Application Reference: 6/2019/3216/COND

Proposed development at: 12 Tolmers Gardens, Cuffley, Potters Bar, EN6 4JE

Proposal: Submission of details pursuant to condition 1 (sample of materials) 2 (crown roof details) 3 (scheme of accessible housing) 4 (balcony flank screens) 5 (hard and soft landscaping works) 7 (cycle store) 8 (bin store) and 9 (shared surface access) on planning permission 6/2018/3125/FULL

job drwg. no: JW820-132 rev: H

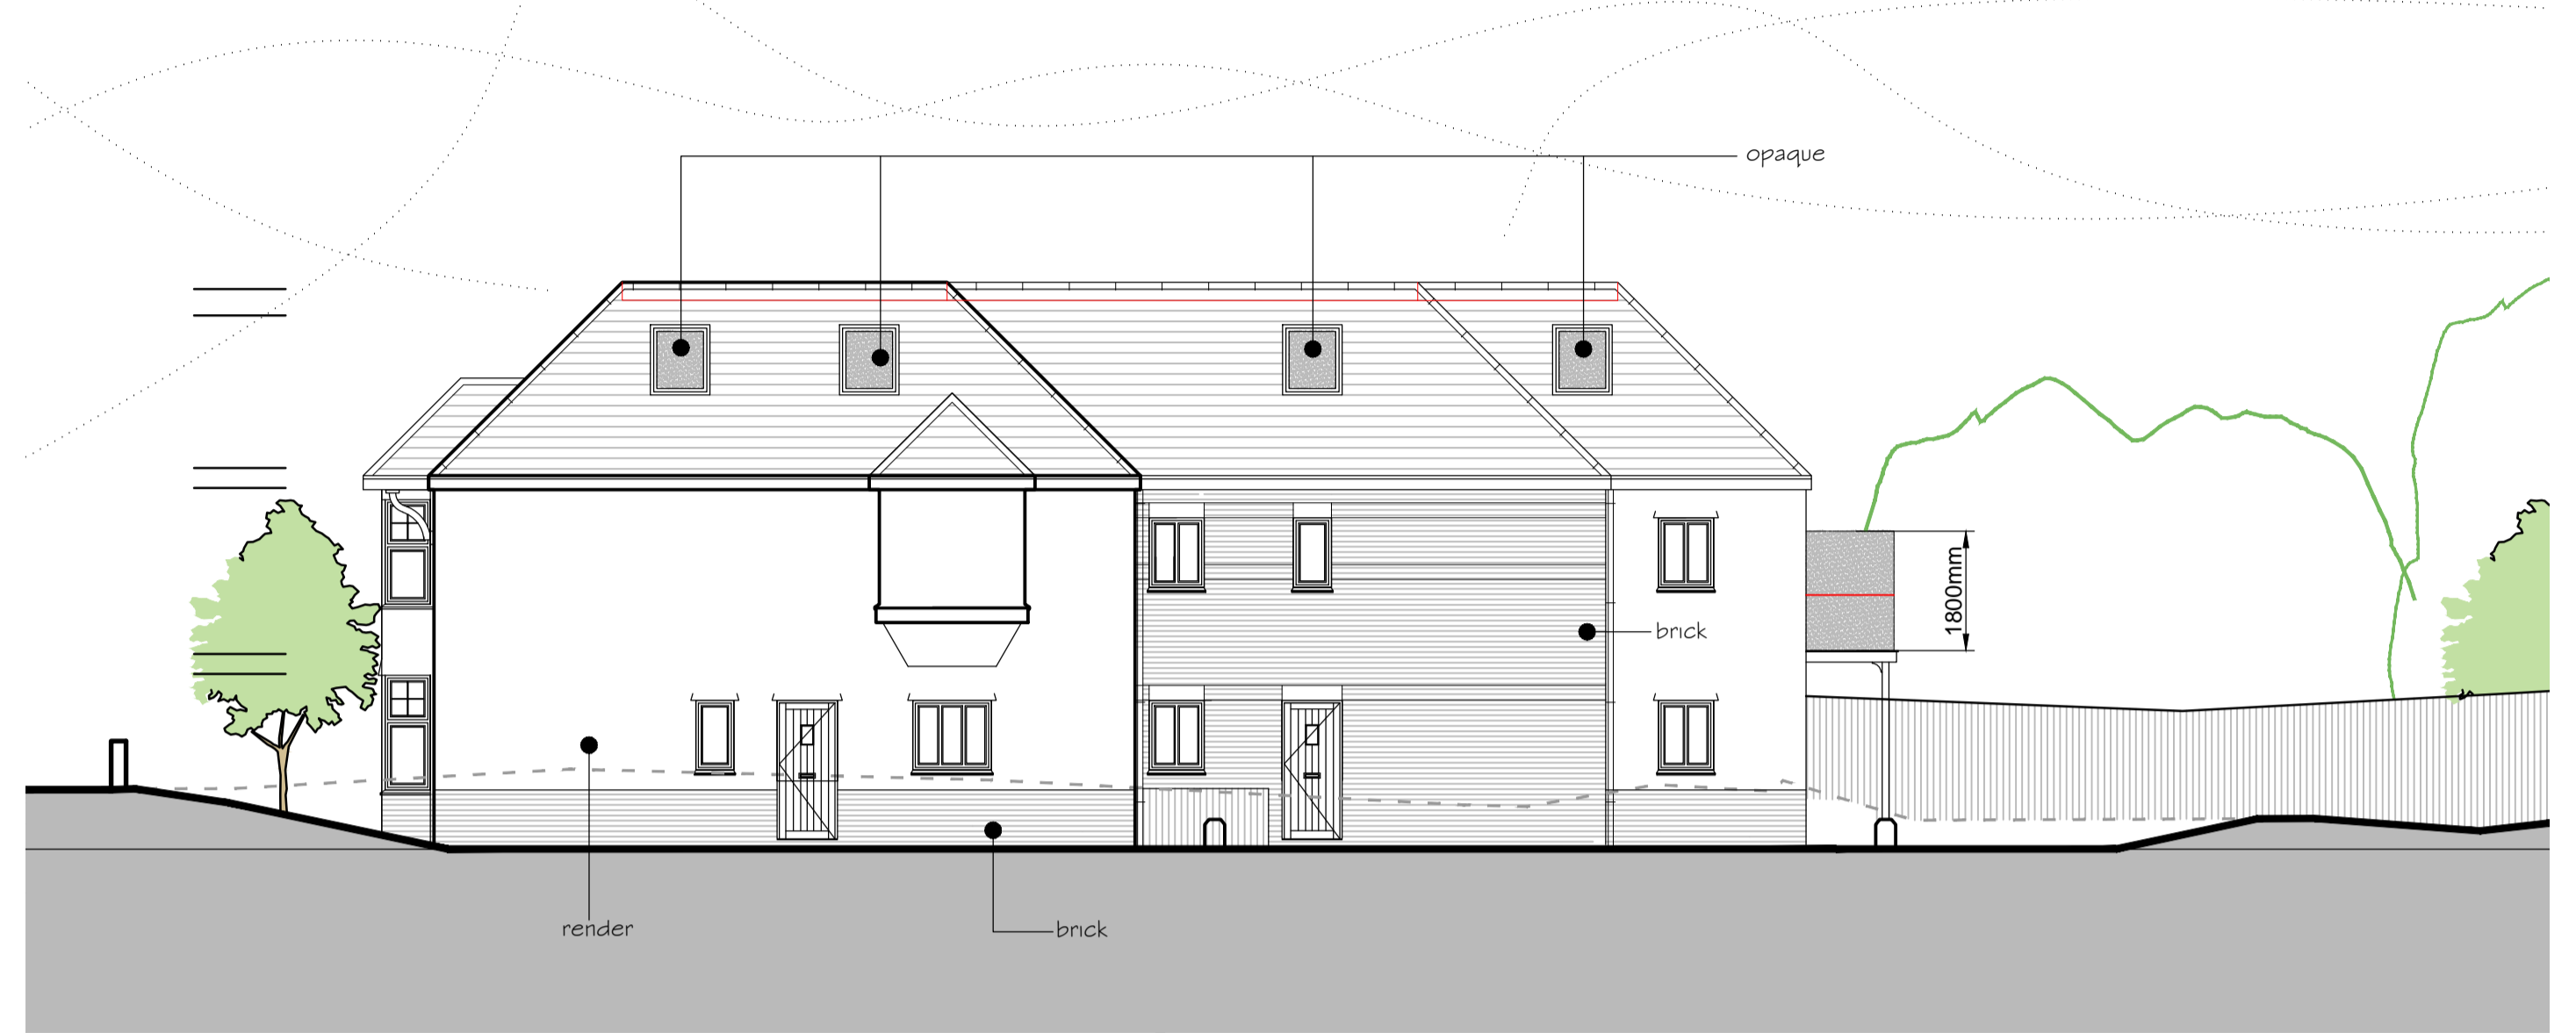
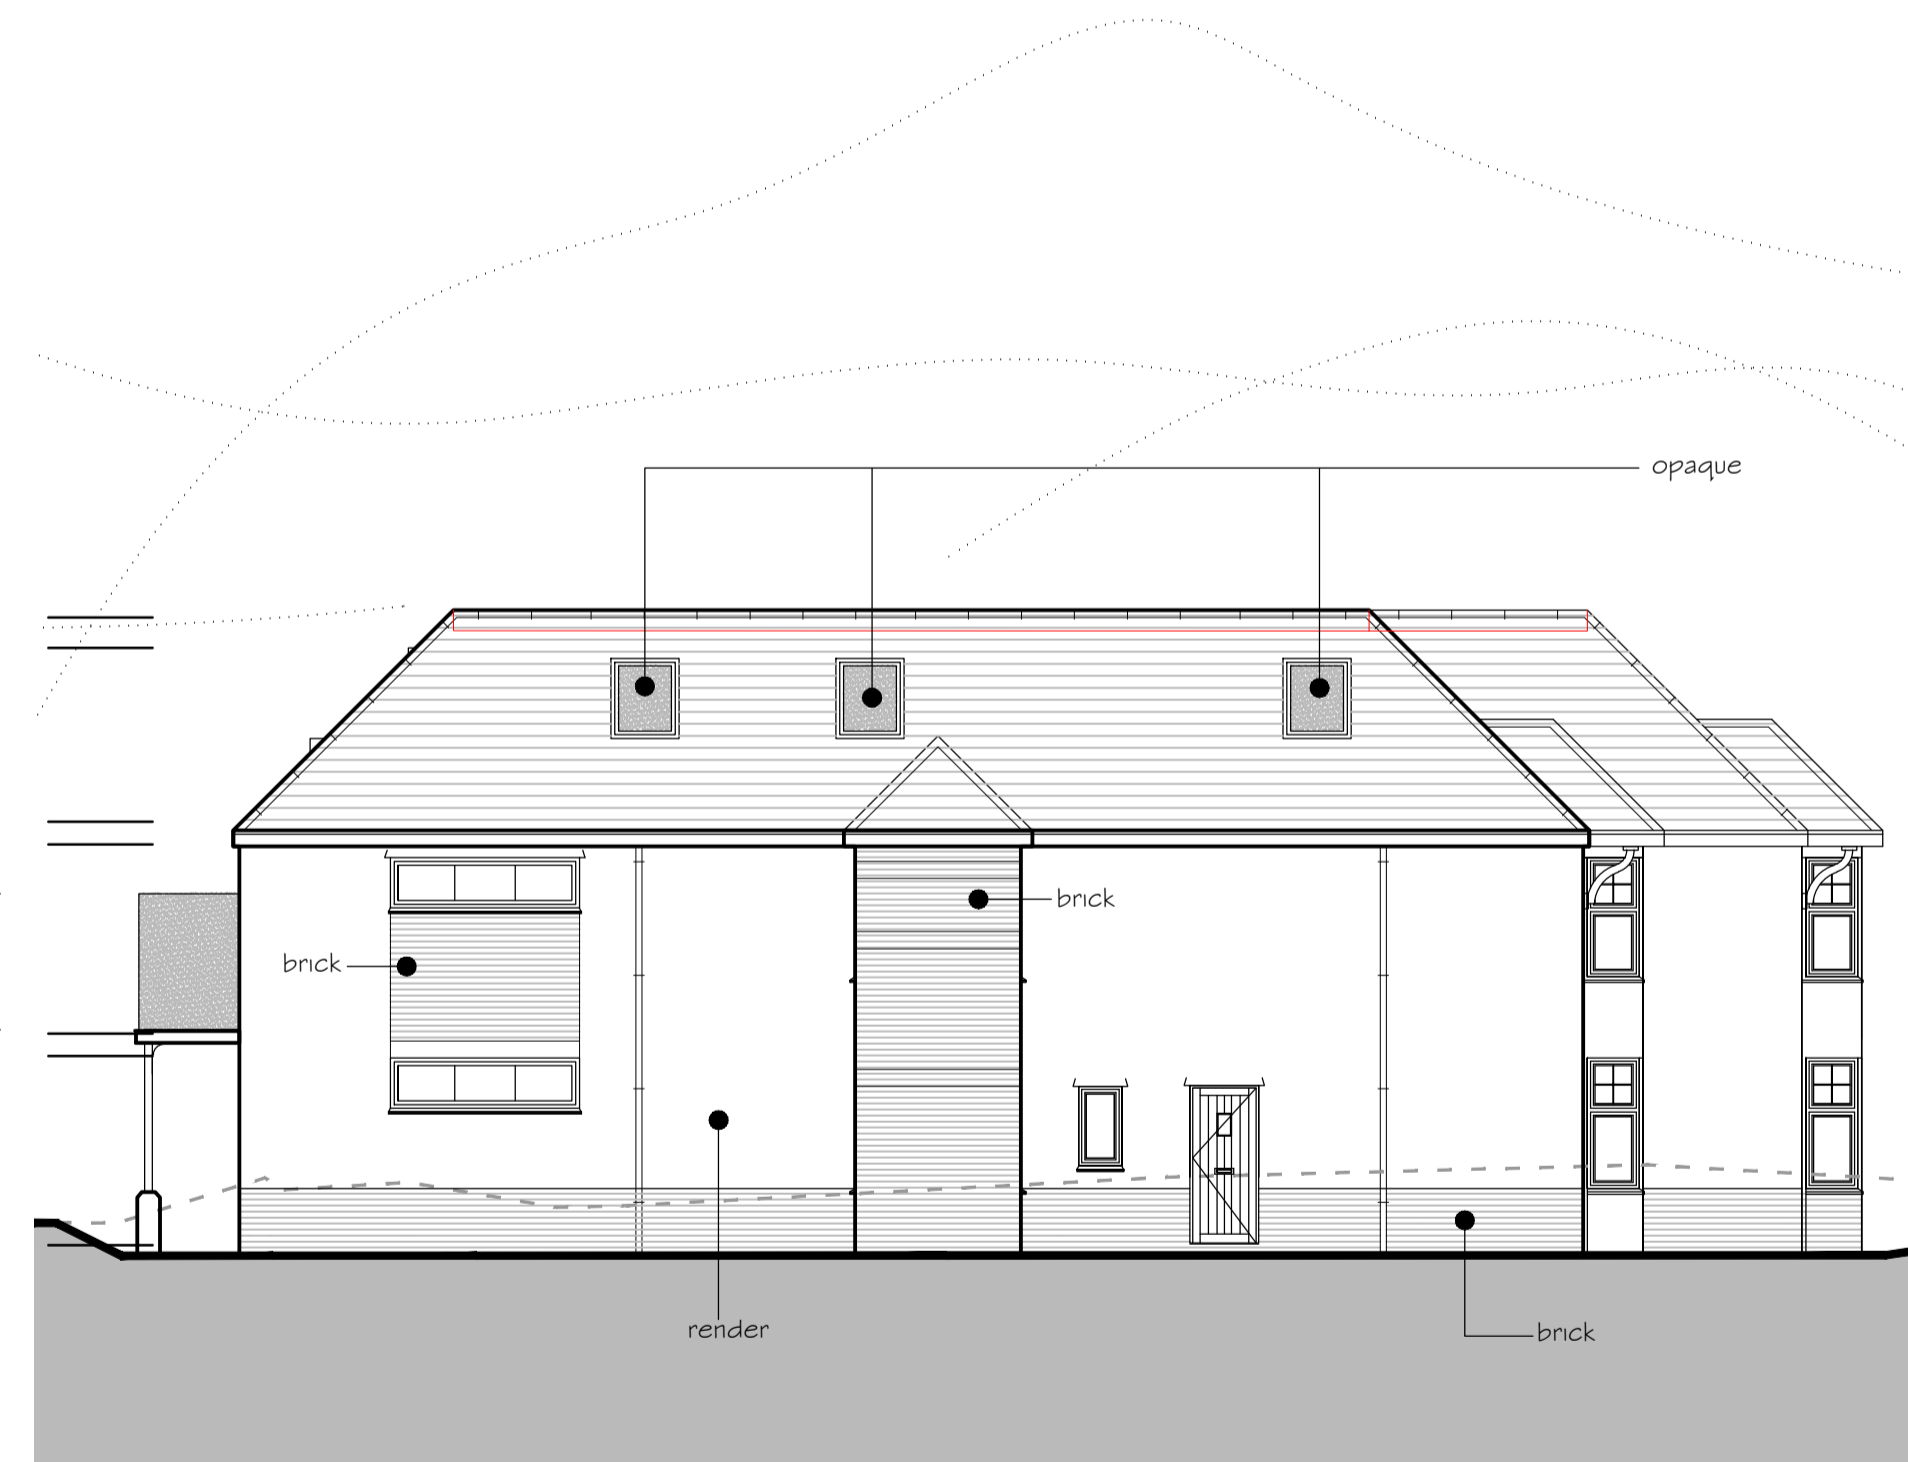
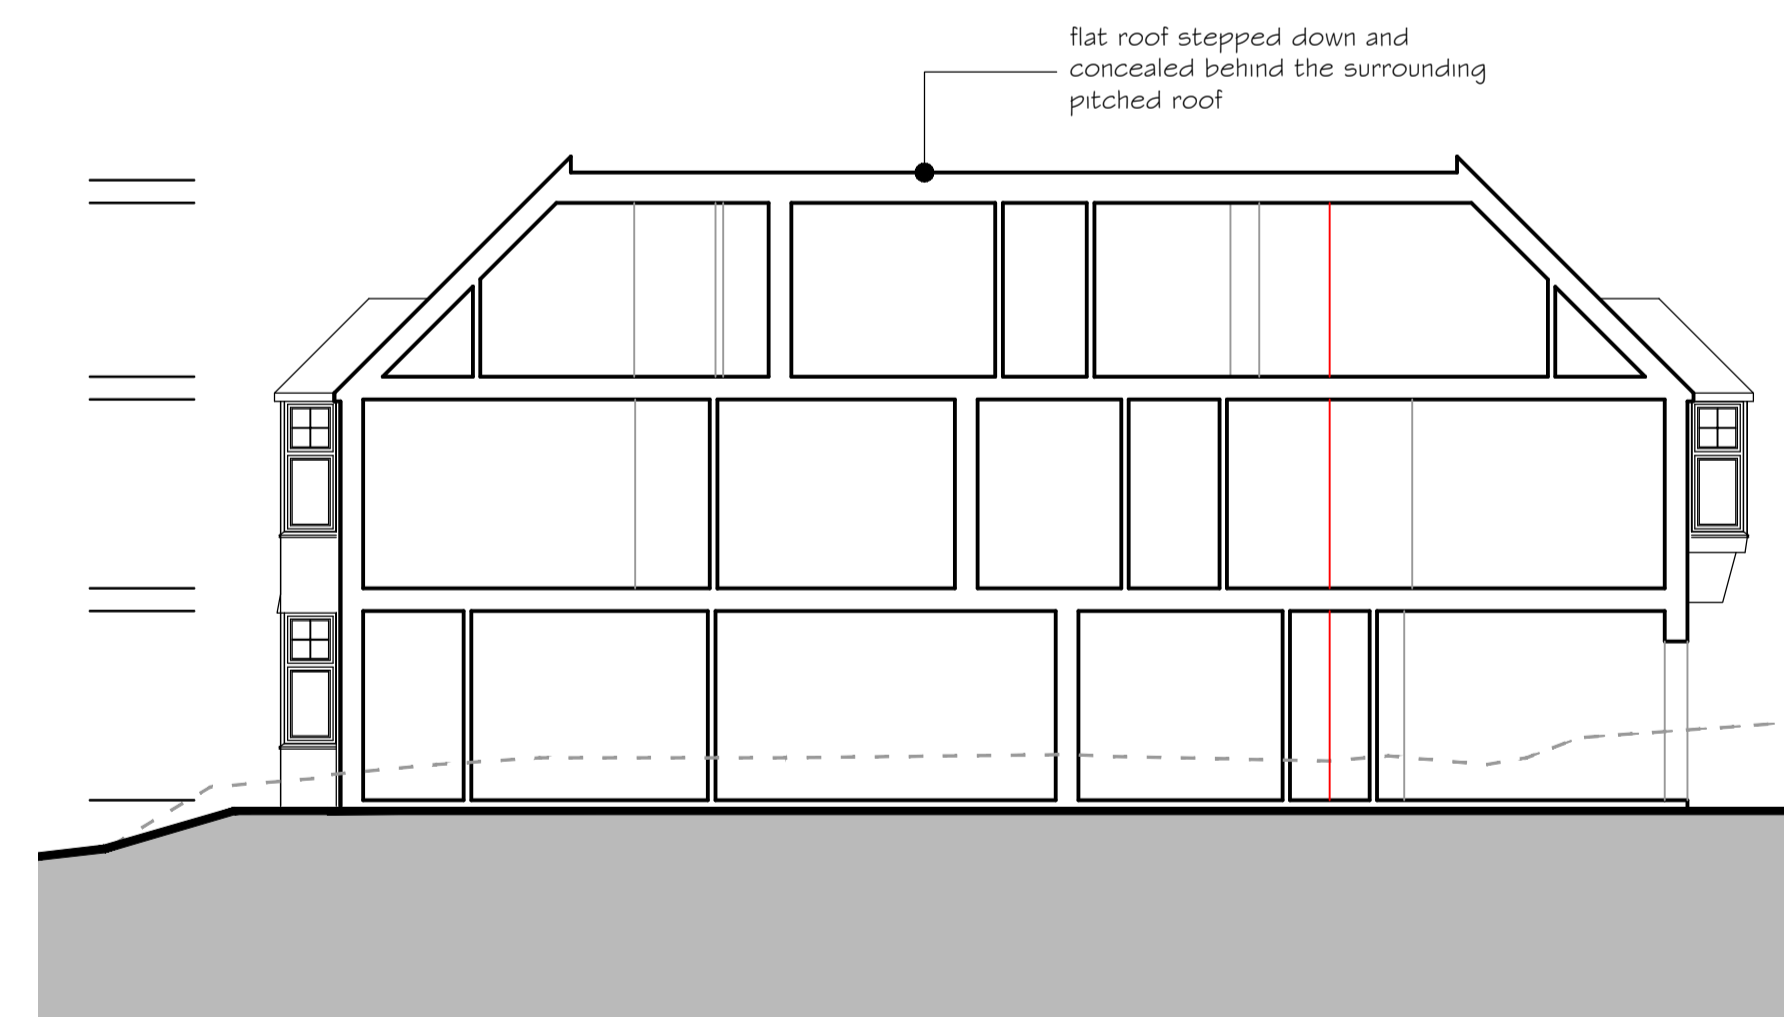
Details of the external materials are shown on the submitted Rev A Materials Schedule. Also, drawing number: jw820-132 Rev A, shows the proportion of brick to render facing on the building. These details are acceptable and approved.

Submitted drawing numbers: JW820-150 and jw820-132 Rev H, together include acceptable crown roof details.

job drwg. no: JW820-C3-144 rev: A

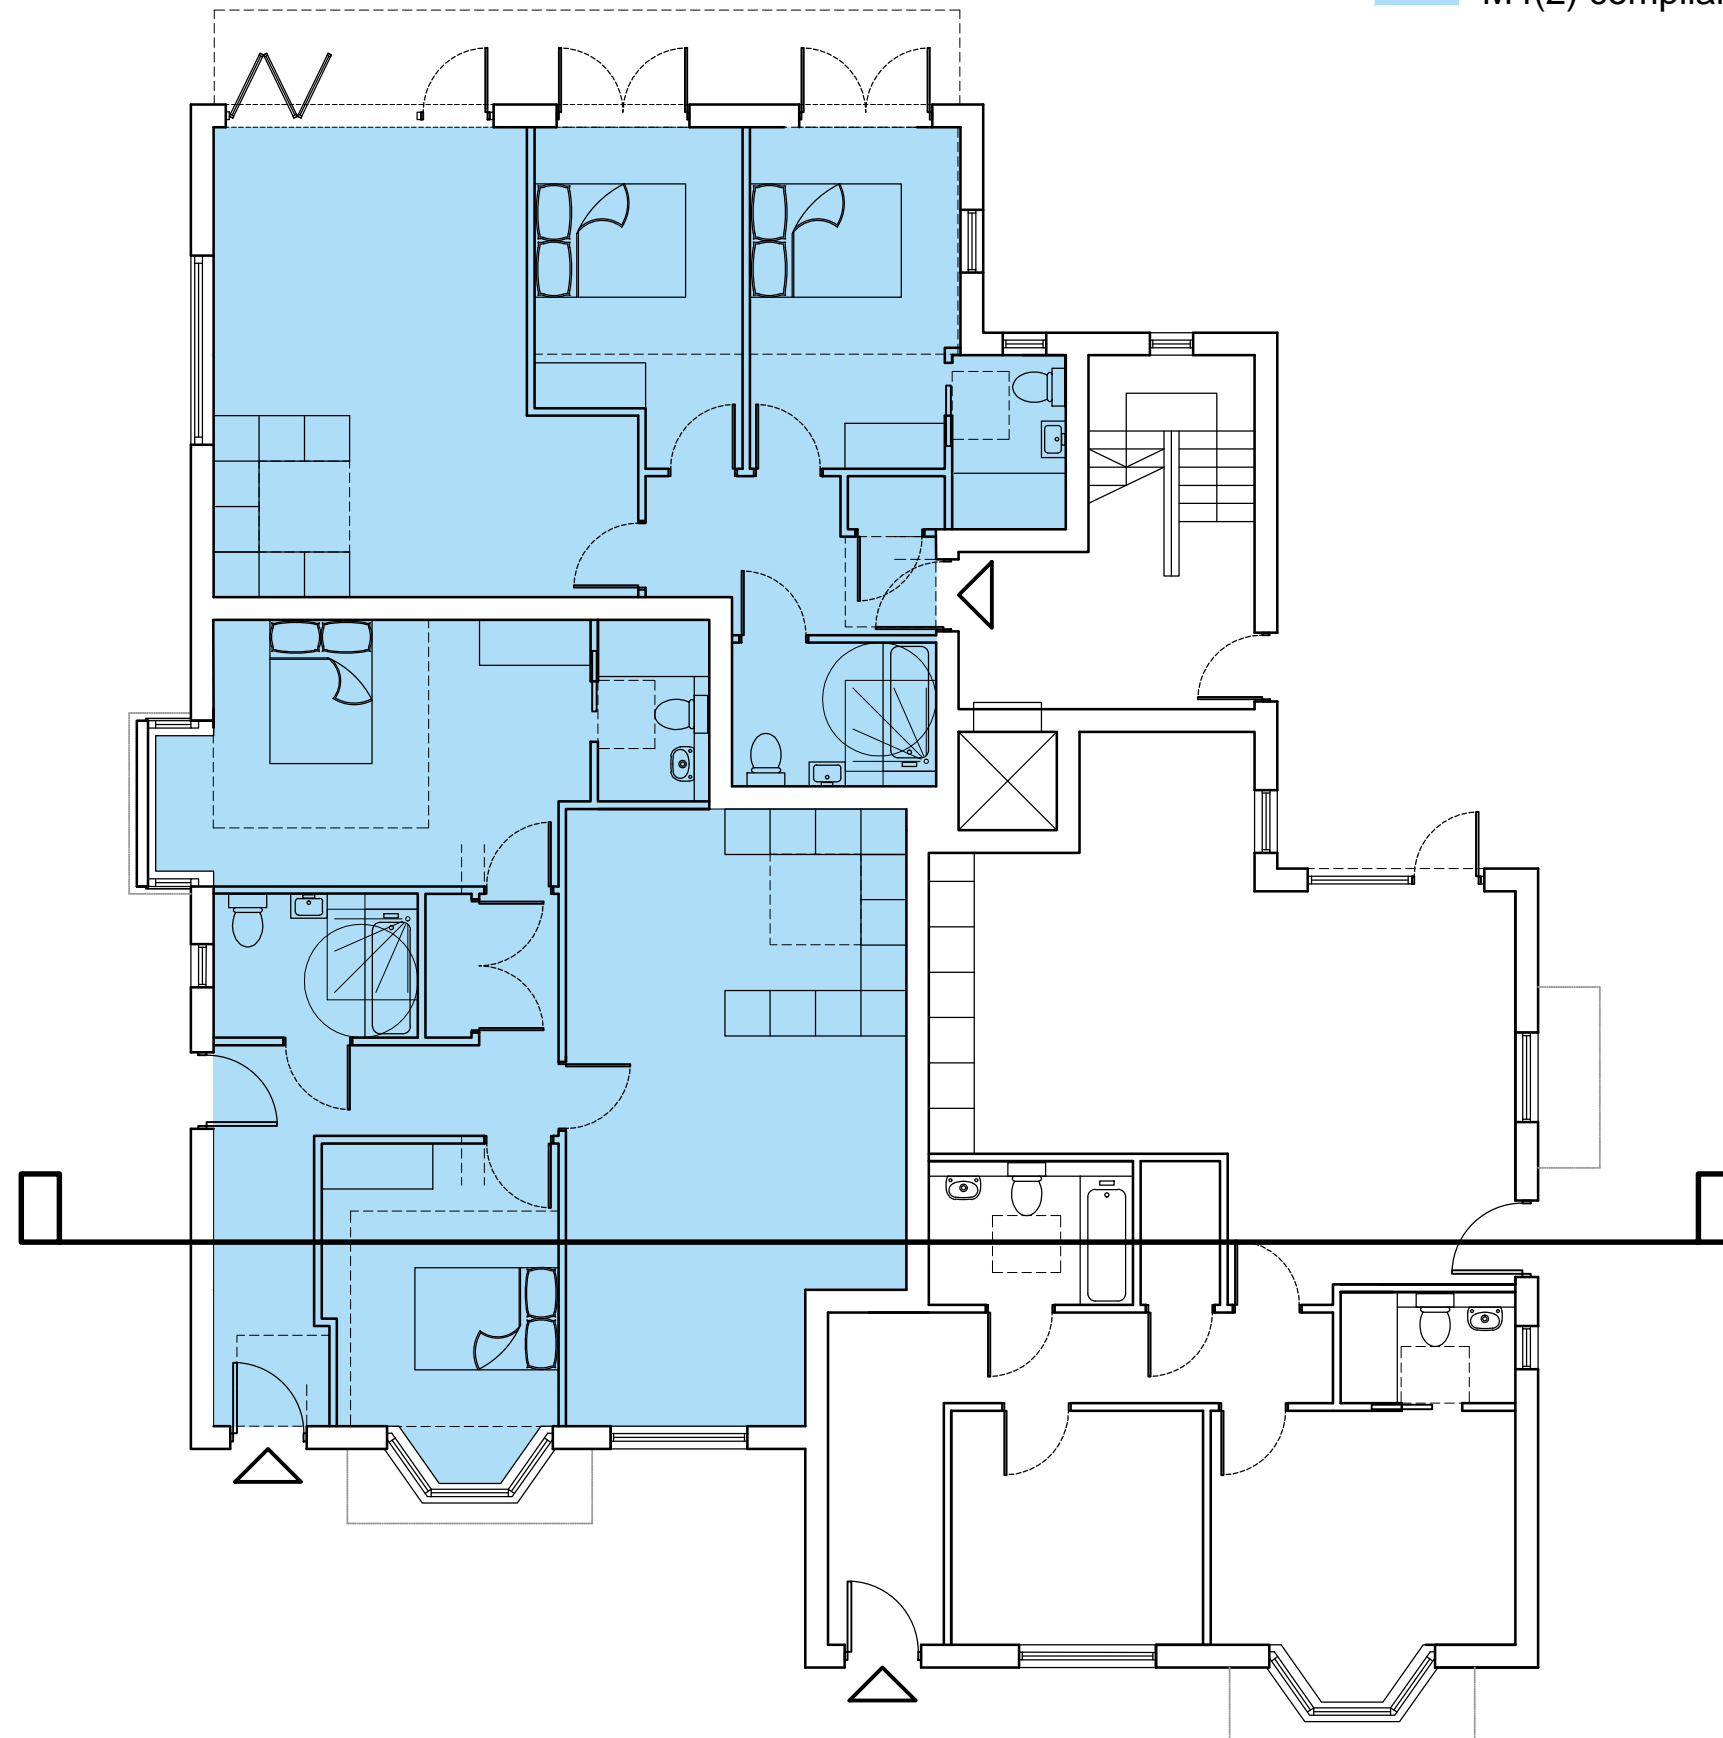
Part (a) is sought to be discharged under this application. Drawing number: JW820-C3-144 Rev A satisfies the requirements of this part.
